AB/86/19/HH & AB/87/19/L

These comments relate to the revised plans submitted on the 24 September 2019.

This application relates to a single storey rear extension, new deck area, external staircase, removal of hanging tiles at first floor level and infilling a covered walkway area.

PROPOSED PLAN - GROUND FLOOR

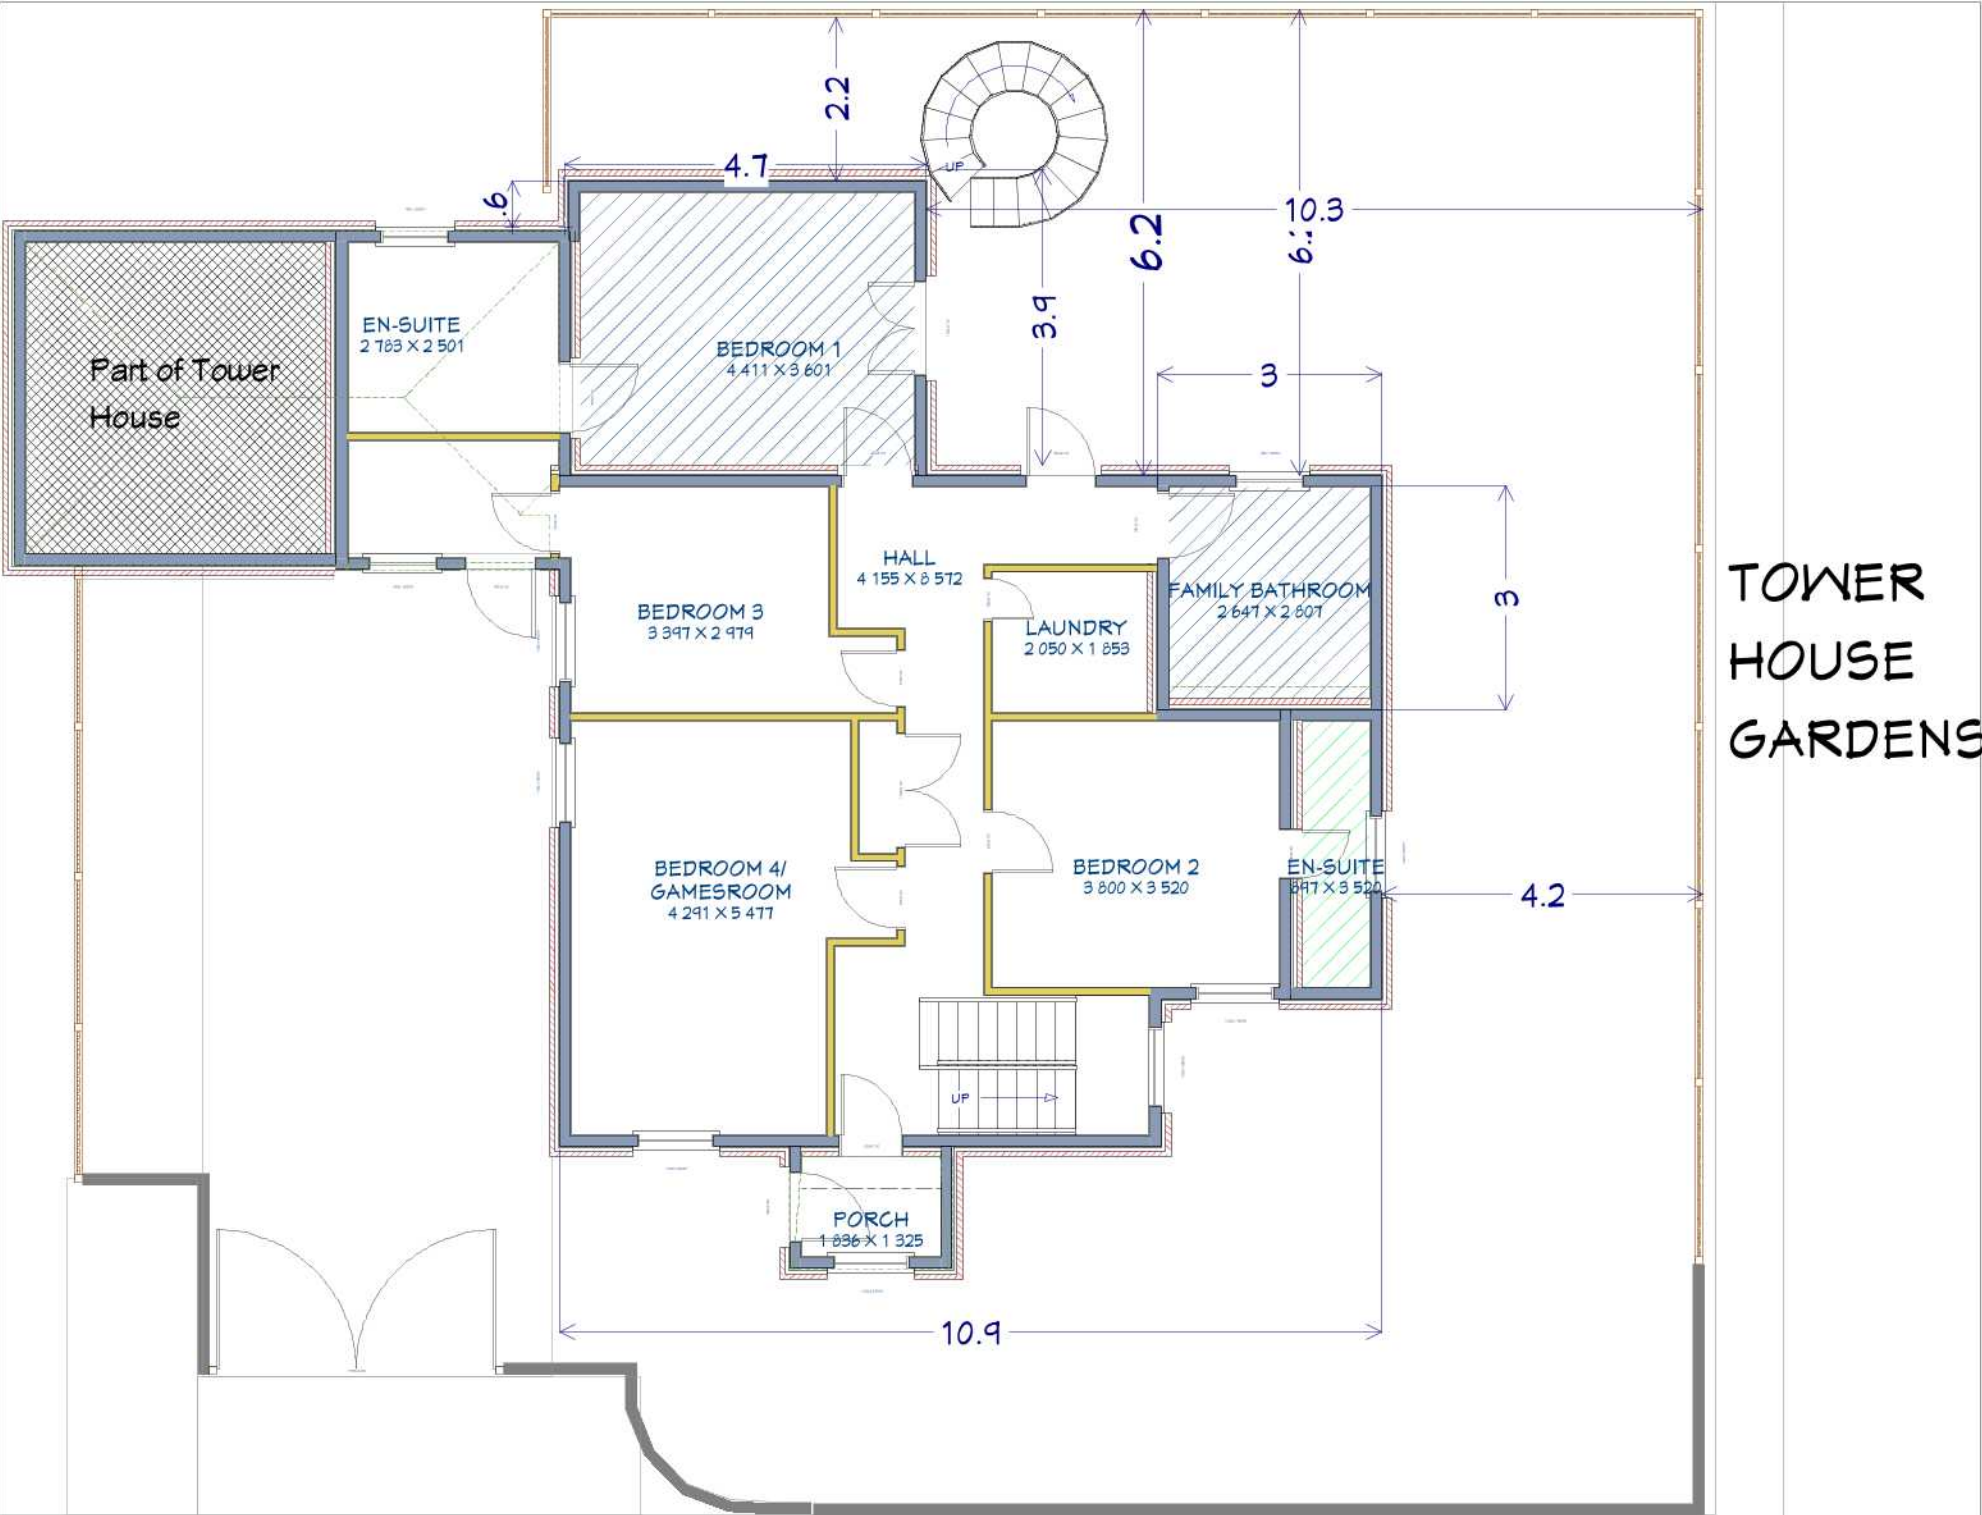
The concept of extending the property is considered to be acceptable, if it is undertaken in a sympathetic manner. Having had the opportunity to review the plans, it is considered that the single storey extension is of a scale that it will have a neutral impact upon the host dwelling. Further, its location is such that it will not have a significant impact upon the street-scene. This comment is made subject to the use of appropriate materials and railings.

It is also considered that enclosing the covered walkway area will not detract from the character of the building or area. This is subject to the brick to be used. The elevations provided for this element partially screen the proposed elevation through the presence of the boundary treatment.

- Details of the brick/brick bond in order to ensure that it matches the existing
- Details of the railings and stairs
- Joinery to match existing
- Details of the proposed southern elevation

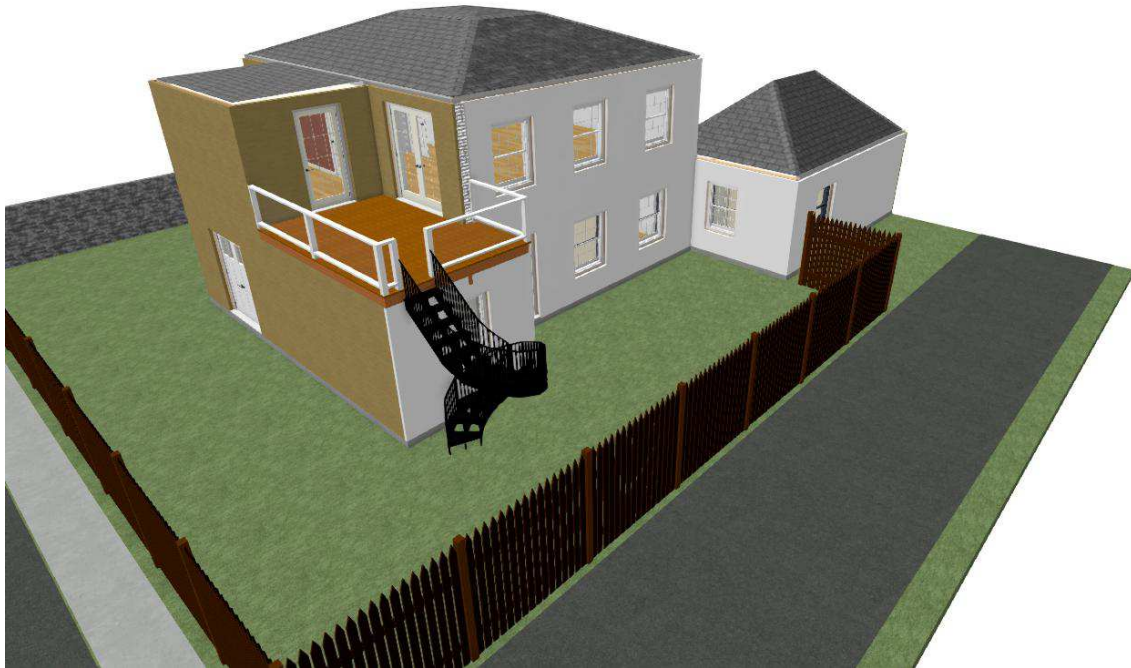
The loss of the tile hangings to the southern elevation will result in the removal of modern fabric which is of no significance. Materials to be used for the proposed render should be suitable for a traditional property such as this one. The final colour of the render should be approved by way of condition

Whilst the concept of replacing a door with a window at the western elevation of the building linking the Mews House and Tower House is acceptable, I cannot see any details/elevations of what this will look like. Will the window occupy all or part of the space currently occupied by the door? At present the elevations do not appear to show this
